TfNSW reference: WST20/00362/03 | SF2020/184623

Your reference: SSD-8950984

SSD-8950984: Response to the EIS Exhibition for the Burrendong Wind Farm

SSD-8950984: Response to the EIS Exhibition for the Burrendong Wind Farm

DRAWING TITLE:
**STRATEGIC DESIGN
 EXISTING LAYOUT PLAN**

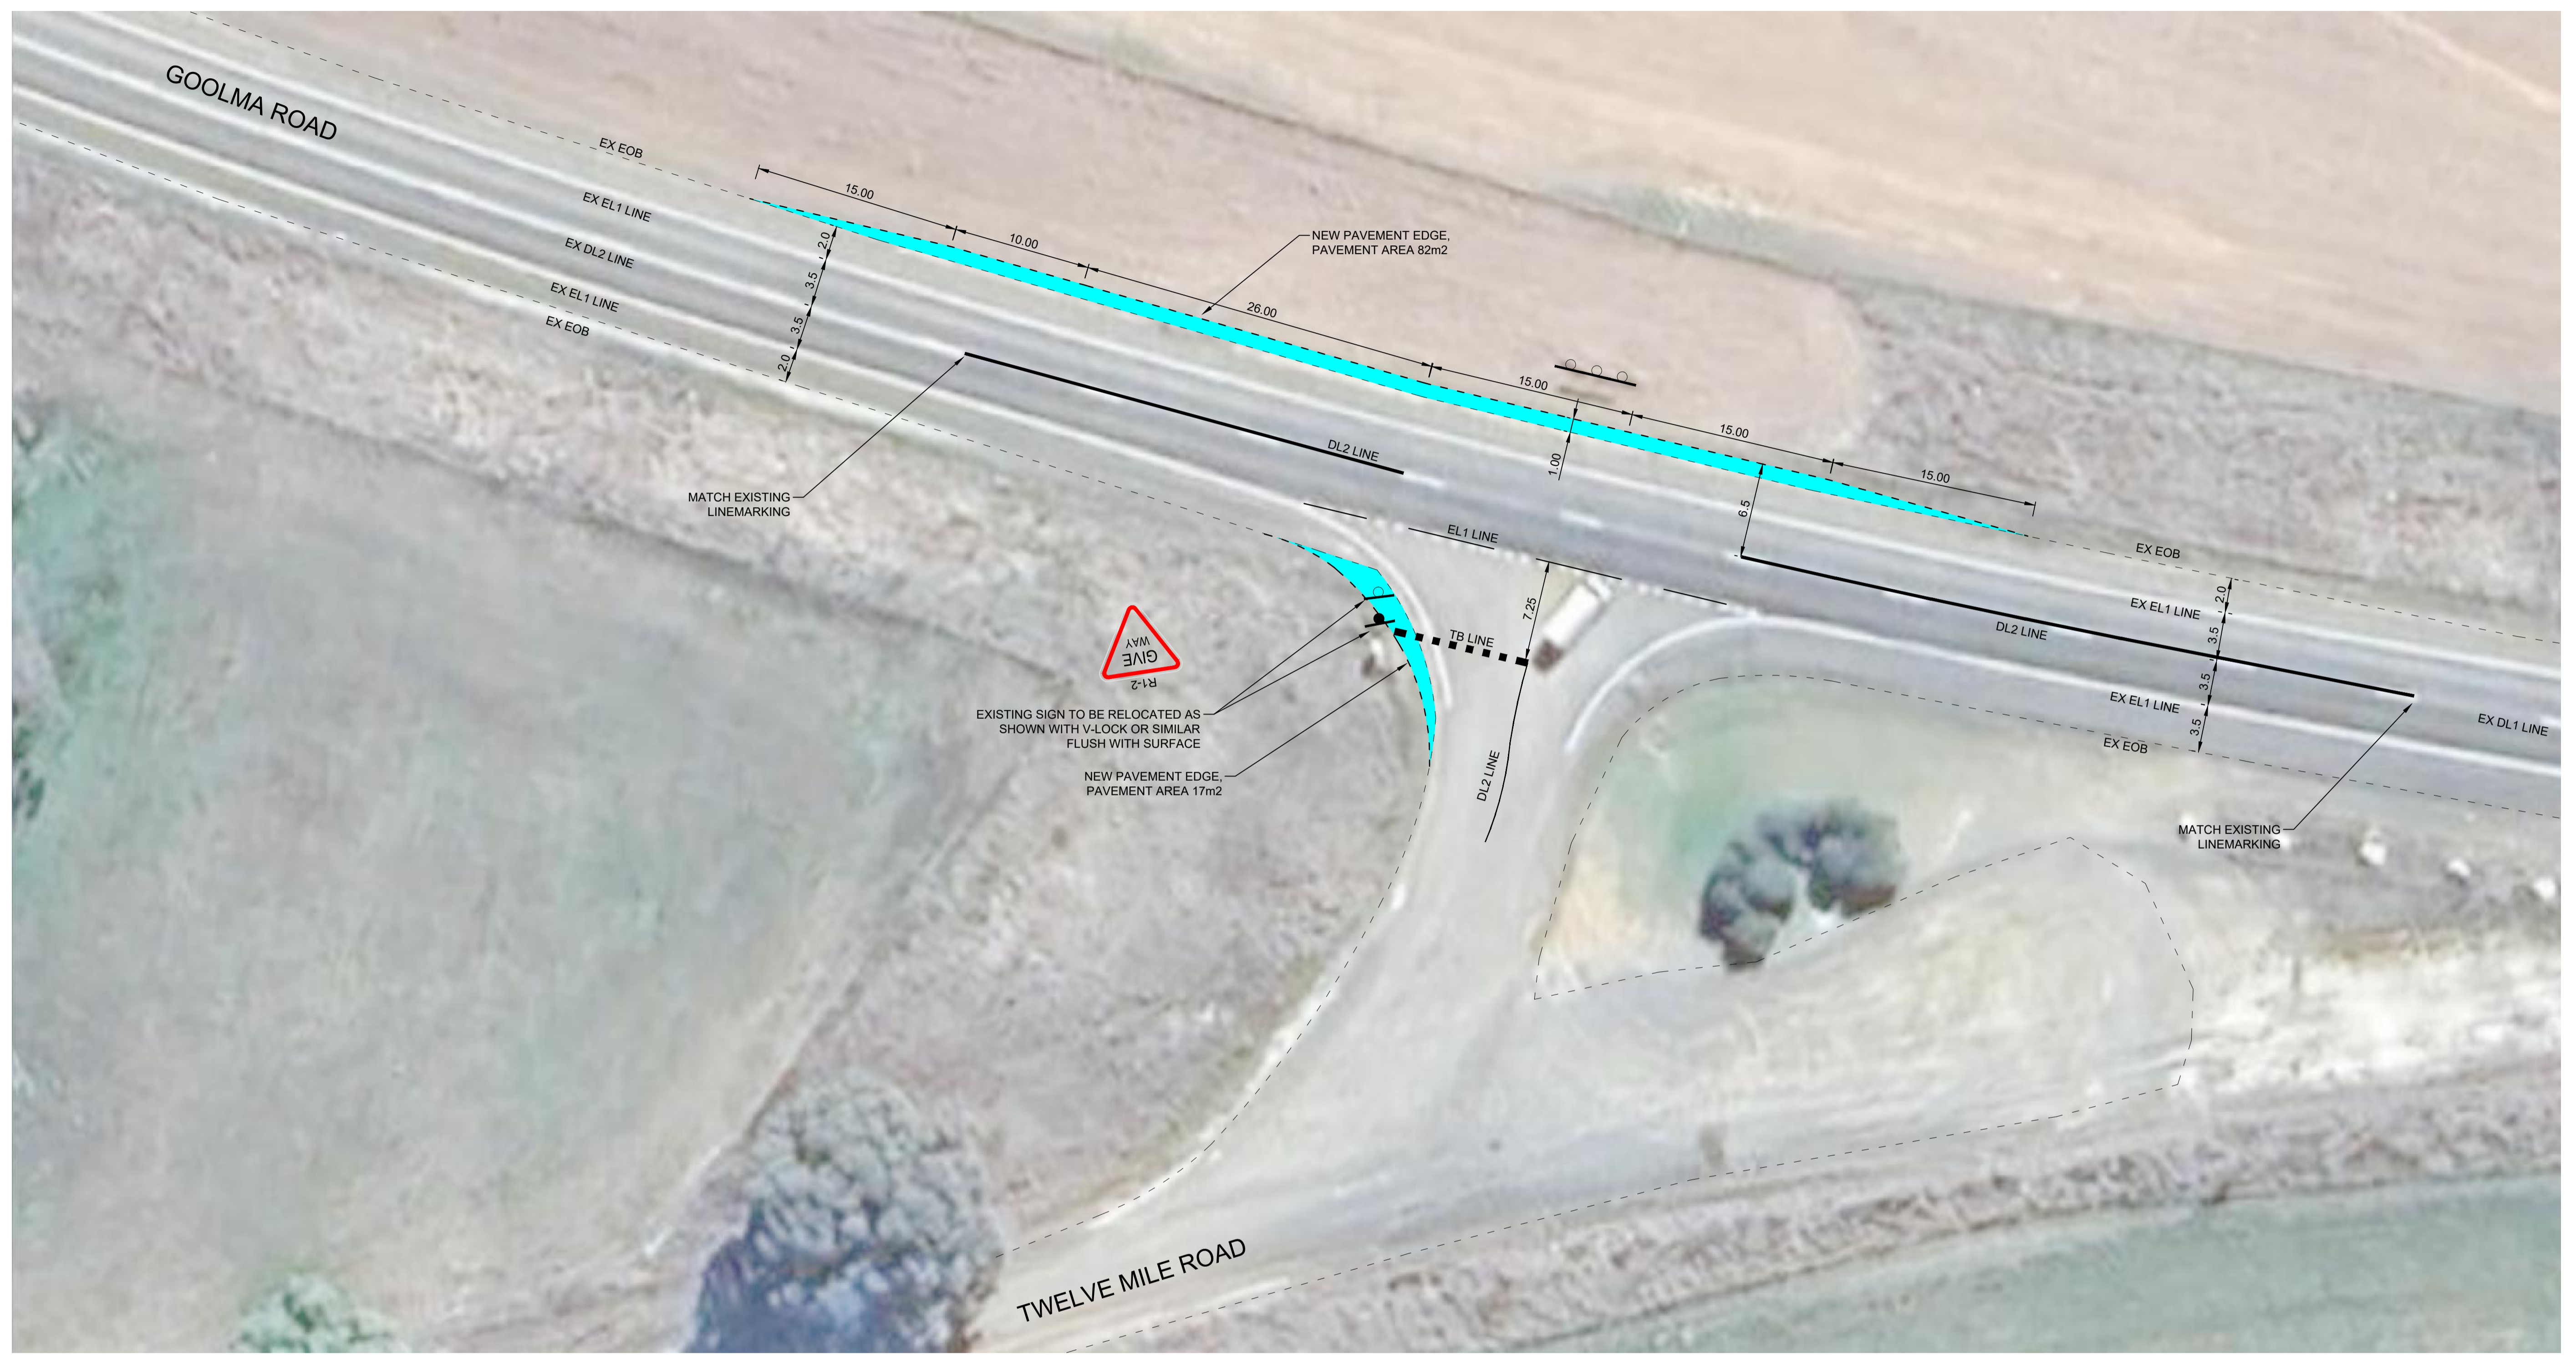
13. Twelve Mile Road/Goolma Road-100km/hr speed zone currently subject to a WAD which was required as a part of the Ungula Wind Farm approval the nature of the work is to realign Goolma Road and Twelve Mile Road and provide a CHR(s) and an AUL. Squadron Energy will be undertaking this road upgrade during 2024. The key aspects and additional information required for this intersection have been identified below:

- a) The cumulative traffic volumes including the through and turning traffic volumes associated with the other nearby projects, existing background traffic (plus growth rate) volumes and the project traffic volumes should be reassessed as a part of the RtS, in relation to the LoS and Turn Warrant Assessment for Goolma/Twelve Mile Road. It is noted that the geometry of the realigned intersection prohibits the provision of a full-length CHR.

- c) The light, heavy vehicles, High Risk OSOM and general OSOM cannot utilise the existing intersection of Goolma/Twelve Mile Road and will have to wait until the completion of the realignment of Goolma/Twelve Mile Road that is currently being undertaken by Squadron for Ungula Wind Farm.

DRAWING TITLE:
**STRATEGIC DESIGN
SWEPT PATH PLAN - OSOM VEHICLE**

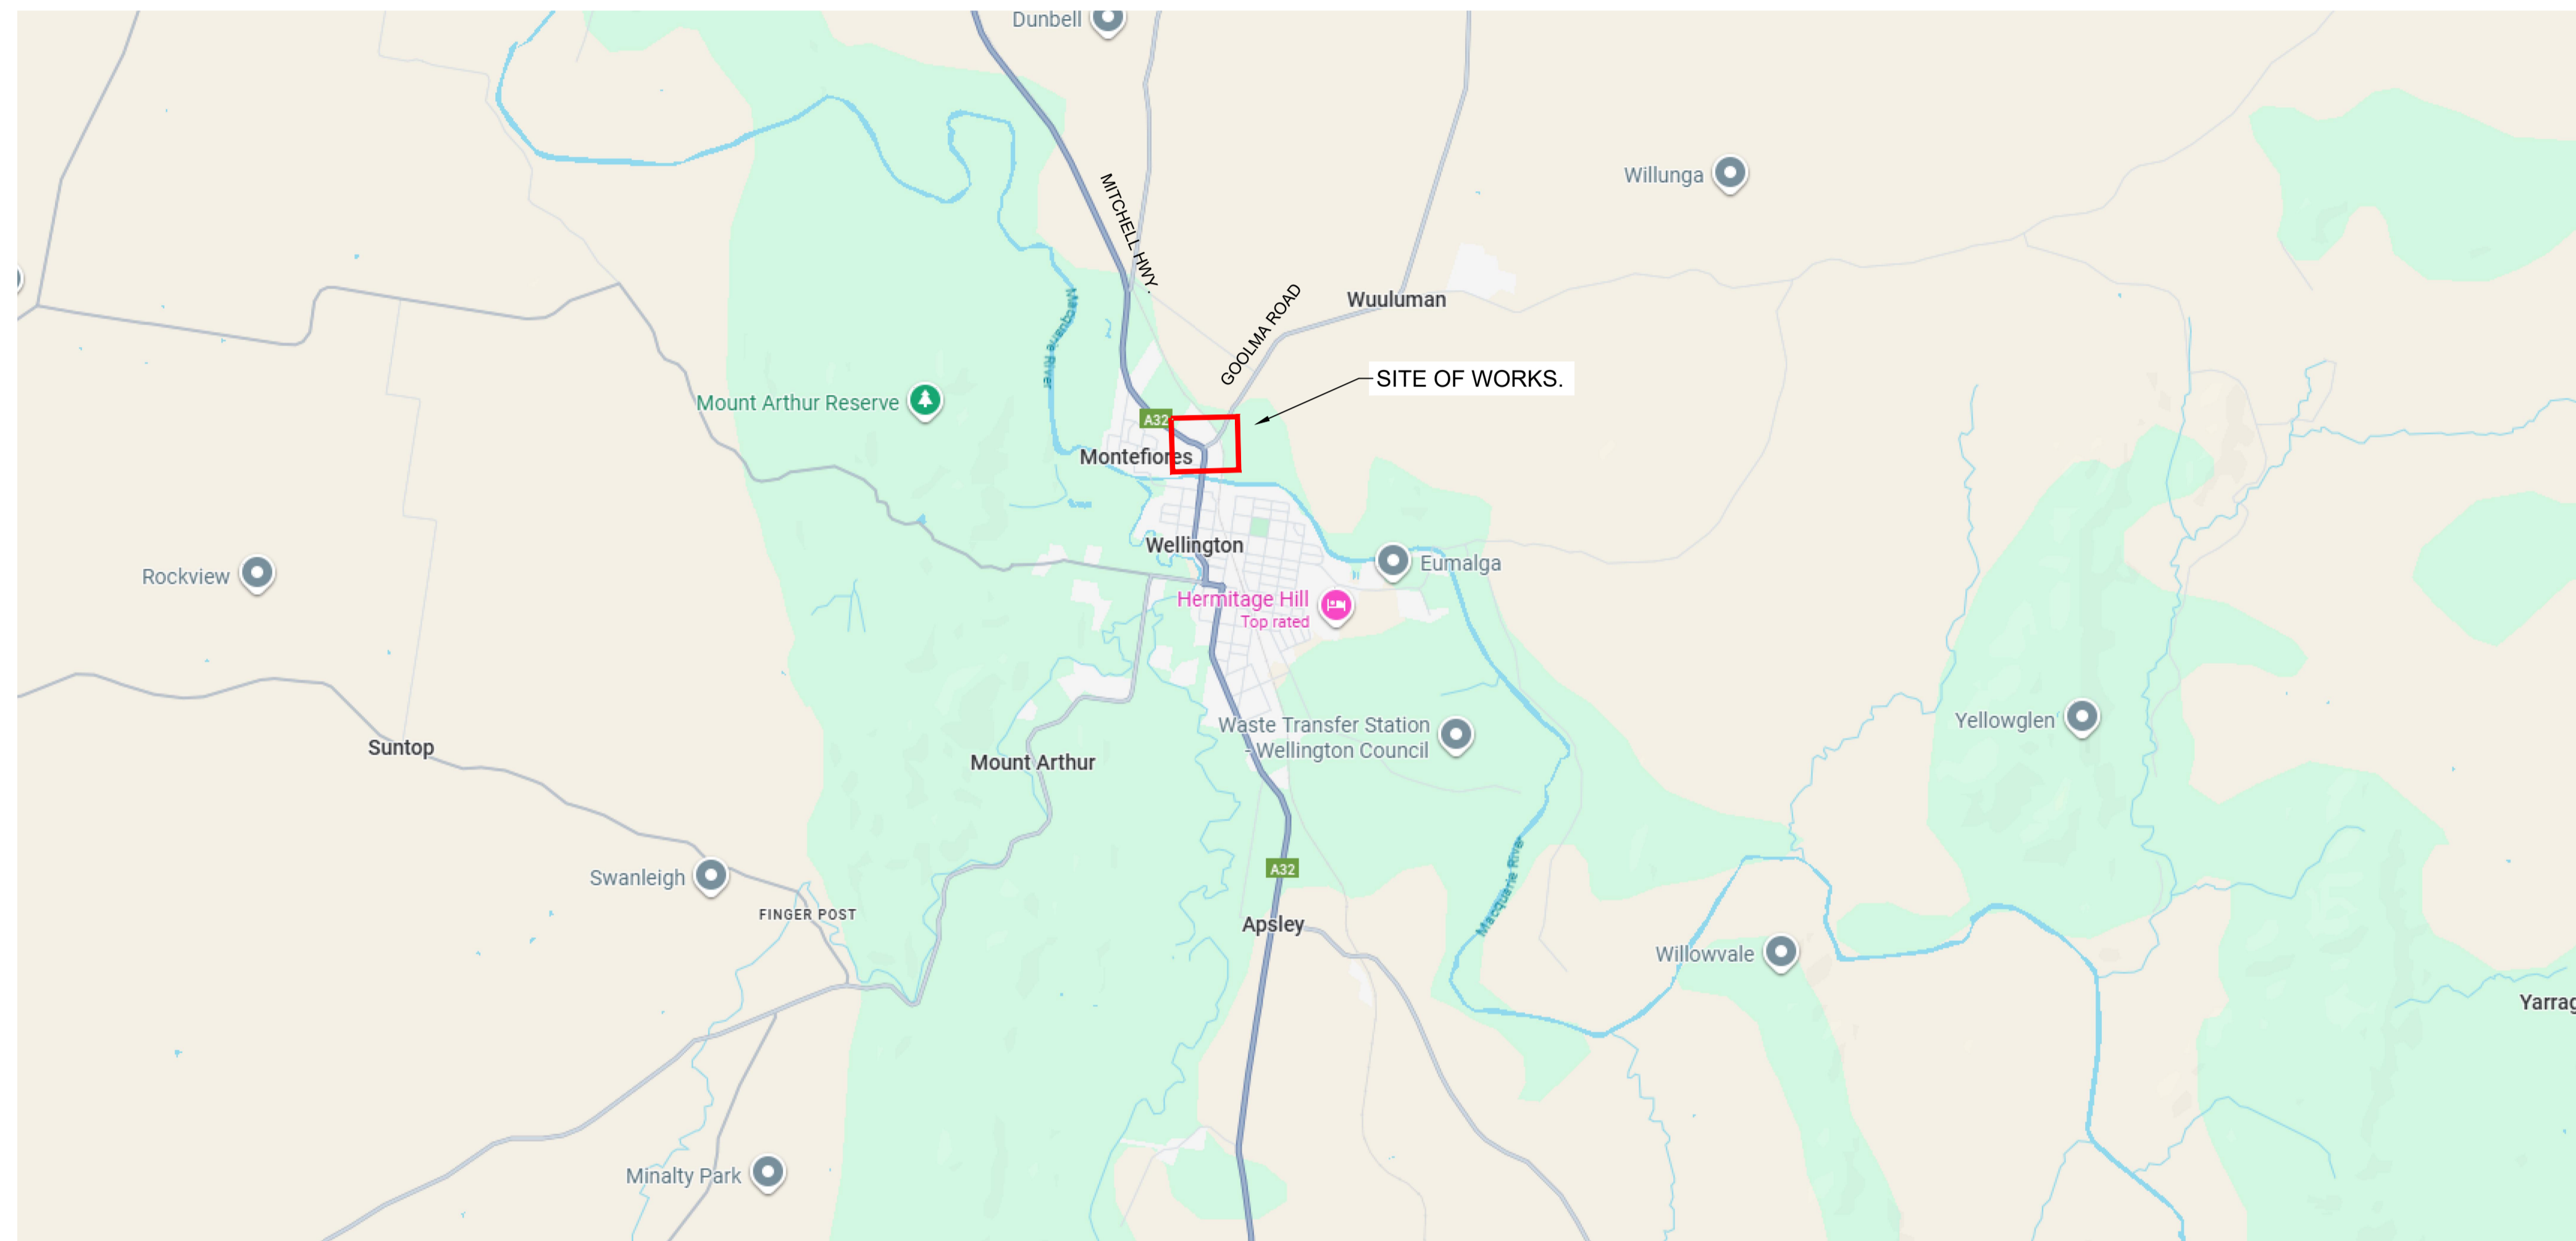
- d) The intersection should be reviewed for the vehicle configuration for the High Risk OSOM design vehicle as the intersection has been designed for an 80.4m blade with overall laden load length of 91.86m.

DRAWING TITLE:
**STRATEGIC DESIGN
 SWEPT PATH PLAN - OSOM VEHICLE**

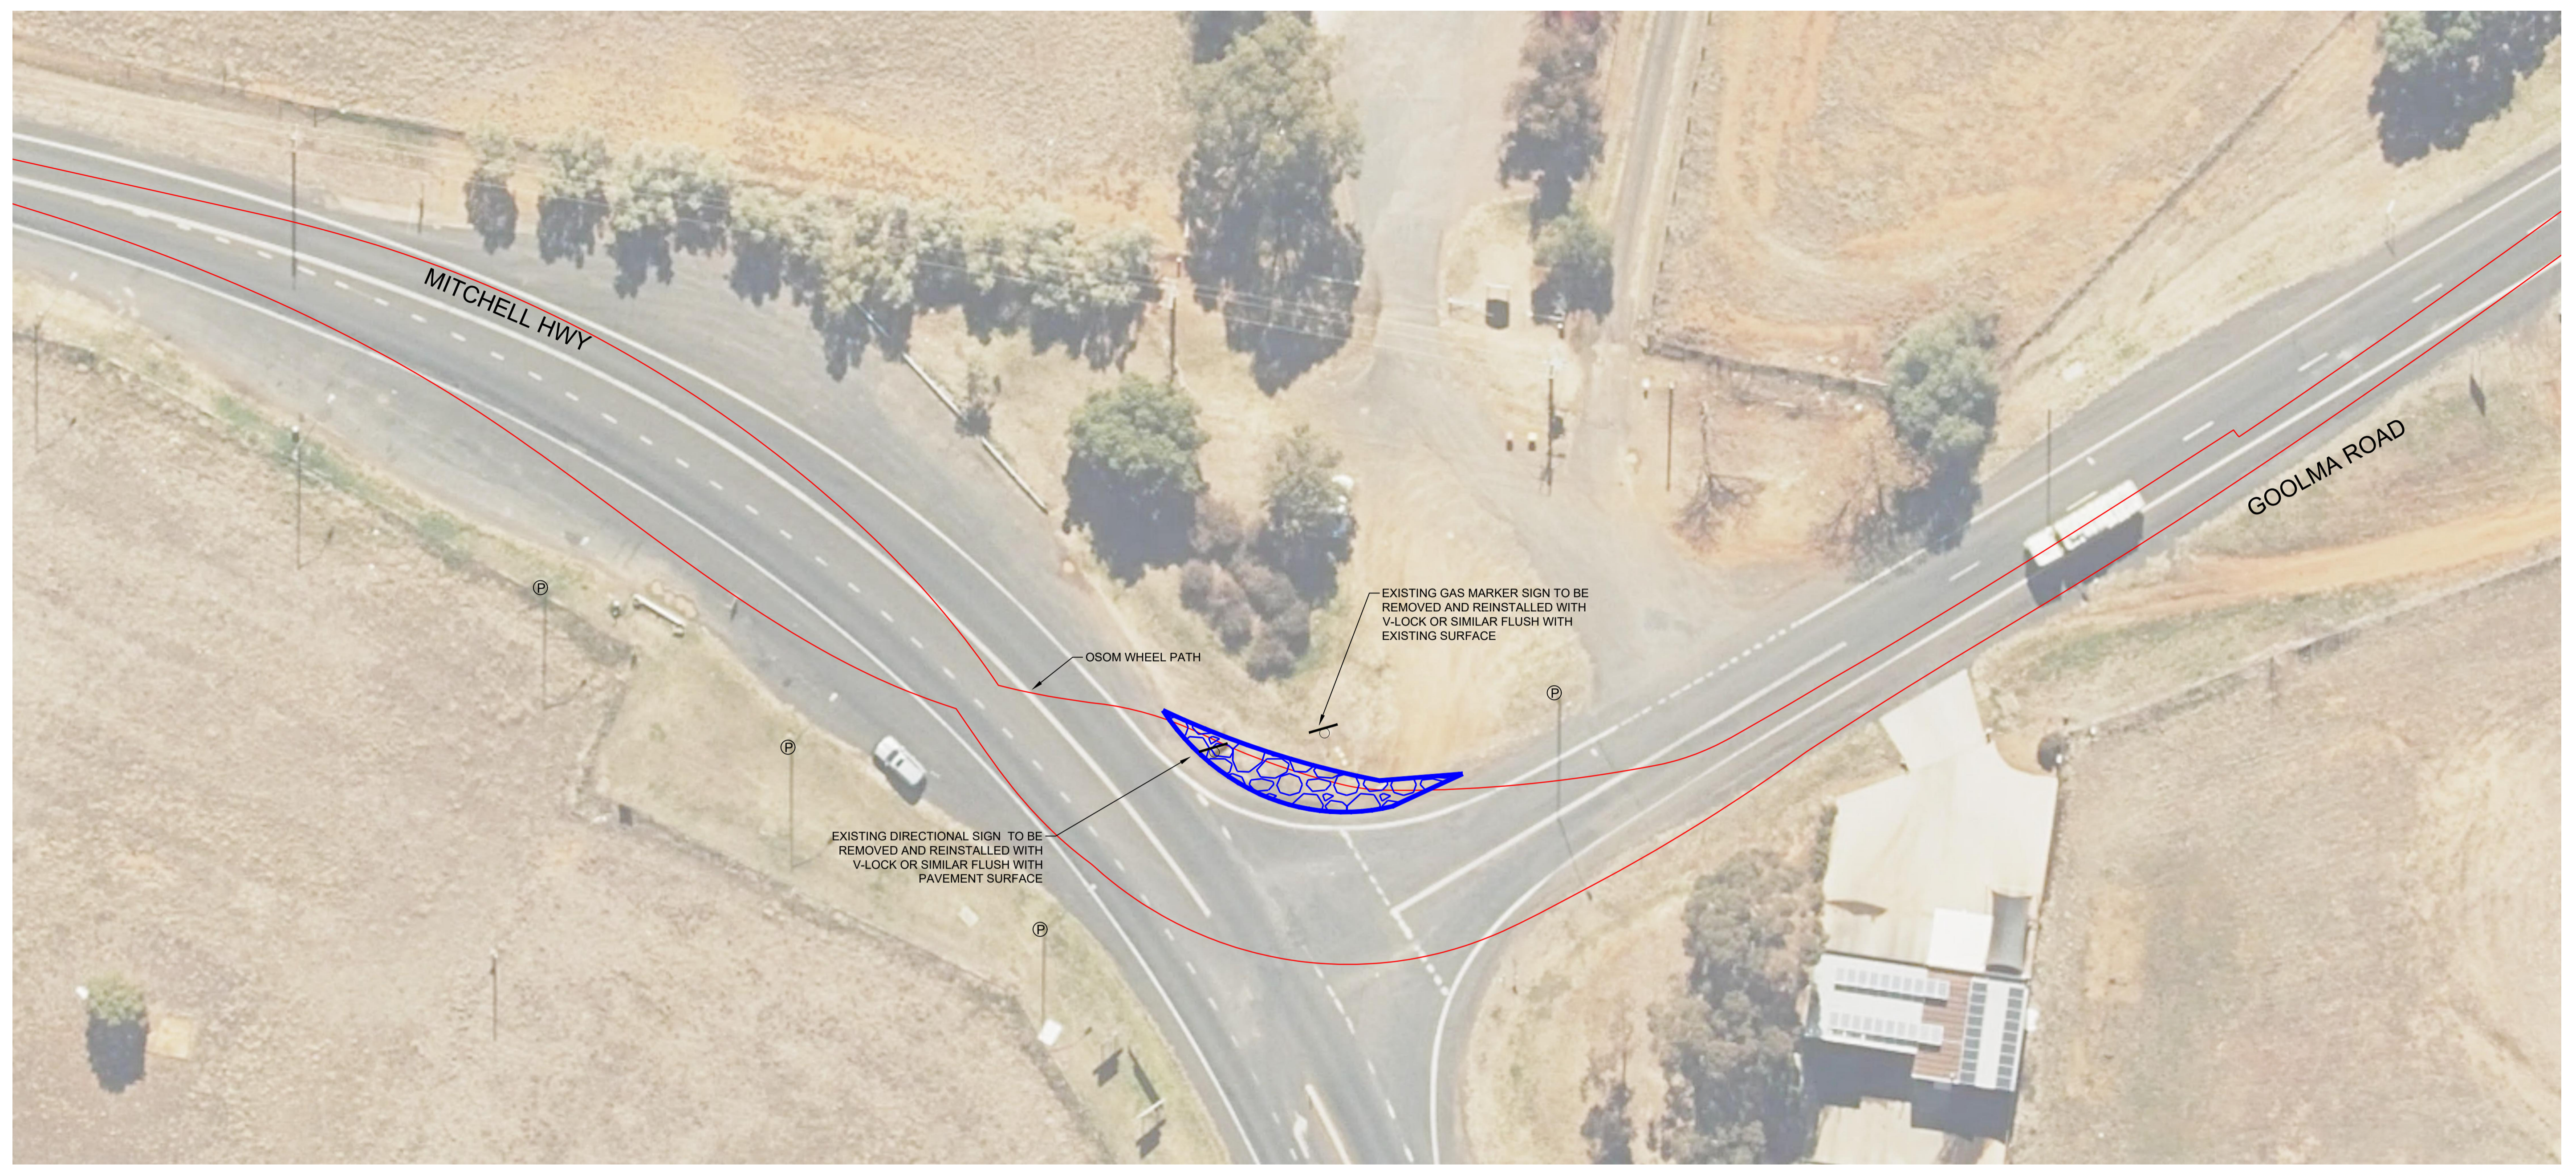
- d) Swept paths should be provided for the High Risk OSOM based on the vehicle configuration and load and any road upgrades required because of the High Risk OSOM review at this intersection should form part of the RTS response.
